**From:** Brad manney <brad.manney@gmail.com>  
**Sent:** Tuesday, March 17, 2015 3:41 PM  
**To:** Jeff Watson  
**Subject:** McIntosh's proposal for event center

While I can appreciate the need for this event center to be available in lower Kittitas County, I have a couple of concerns when it comes to how traffic will be handled.

M MCINTOSH
7820 HWY 97
ELLENSBURG, WA 98926

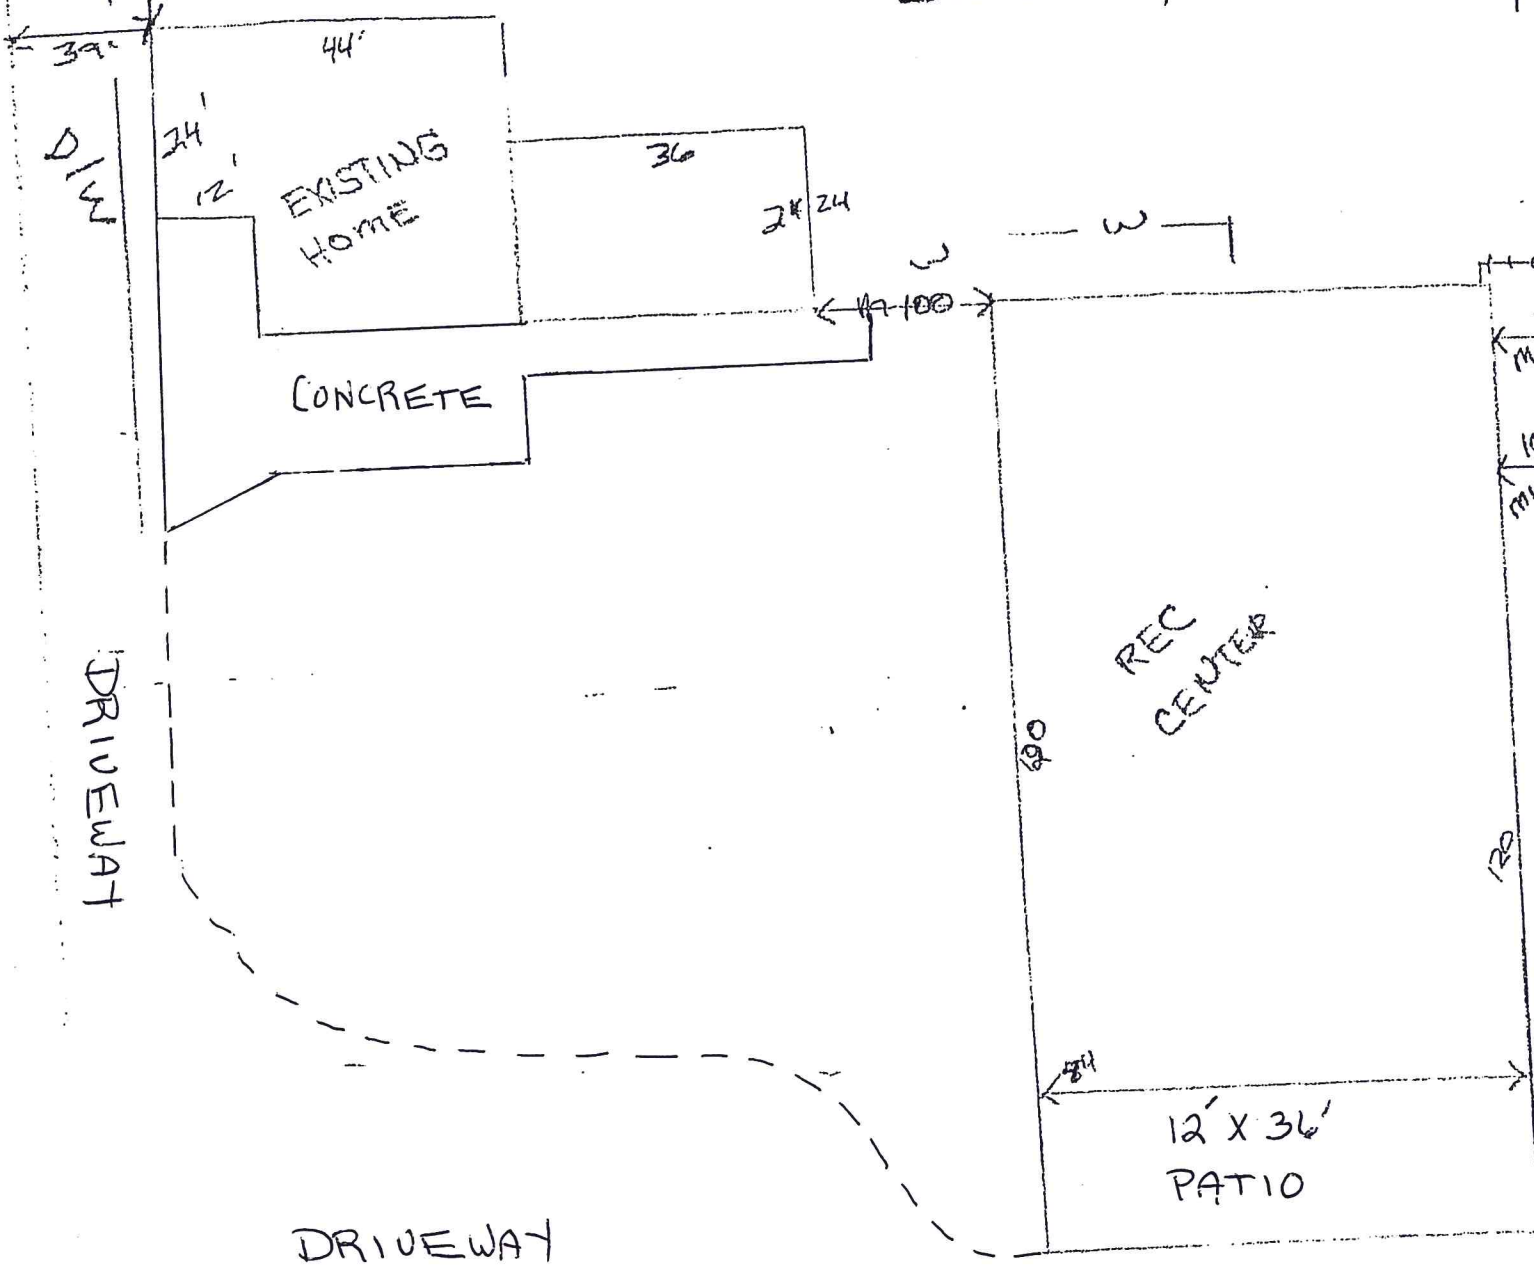
I rent a place a little farther north of the McIntosh's and have had to deal with major traffic issues when events are being already being held at the location. Due to the high speeds on the roadway, I feel that this something that needs to addressed as cars are entering and leaving the busy road. There are pictures from a funeral held at the property which show a bunch of cars lined up on the shoulder. This poses a safety risk for people driving as well as people parked.

The entry and exit back onto the road is not the most visible. The cars are coming up a hill to enter the roadway. This may prove to be an issue if cars and coming and going late at night in the area and there is no lighting that reaches the highway.
